DOC19/1038631

28 November 2019

**Western Sydney University Bankstown City Campus (SSD 9831)  
Advice on the Environmental Impact Statement (EIS)**

PROJECT  
**BANKSTOWN CITY CAMPUS DEVELOPMENT**  
74 RICKARD RD.  
BANKSTOWN NSW 2200  
DRAWING TITLE  
**PLAN - LEVEL 18**

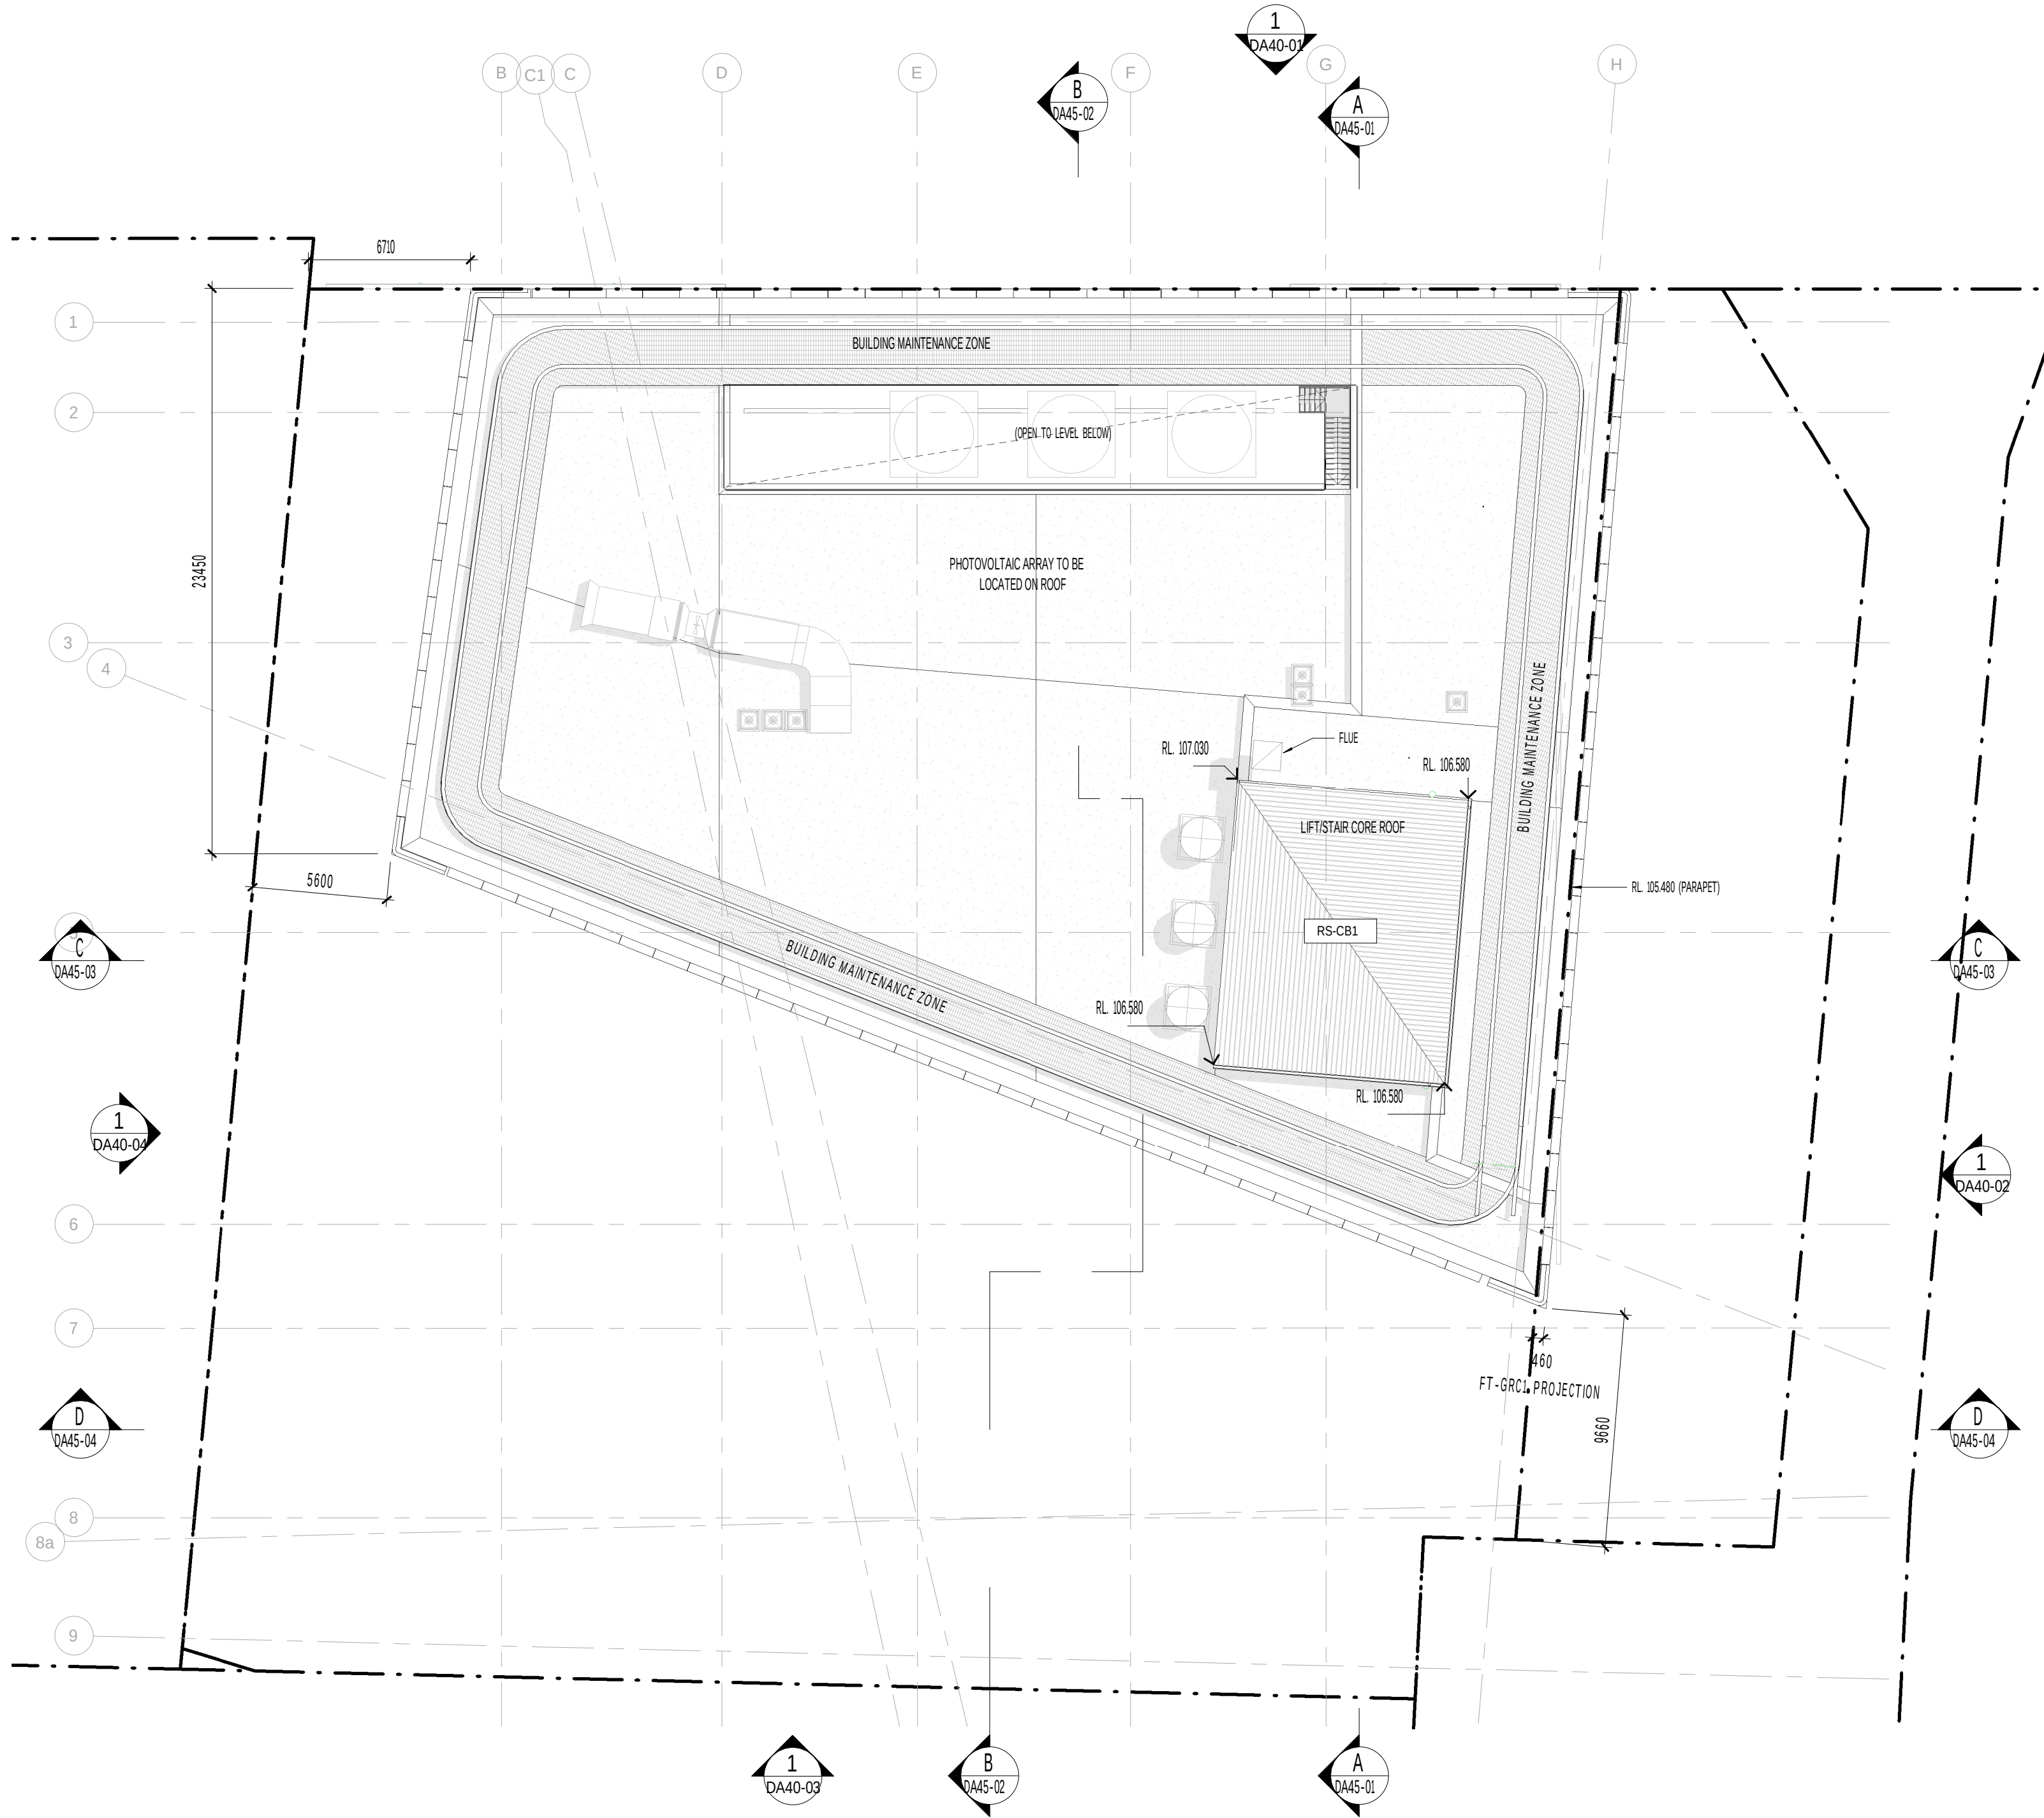
- Plant on northern side of level 18 are close to the residential receivers at 61-63 Rickard Road. No feasible and reasonable alternative consideration is provided regarding layout and options to protect these receivers by orientating the plant to the southern facing side of the building.
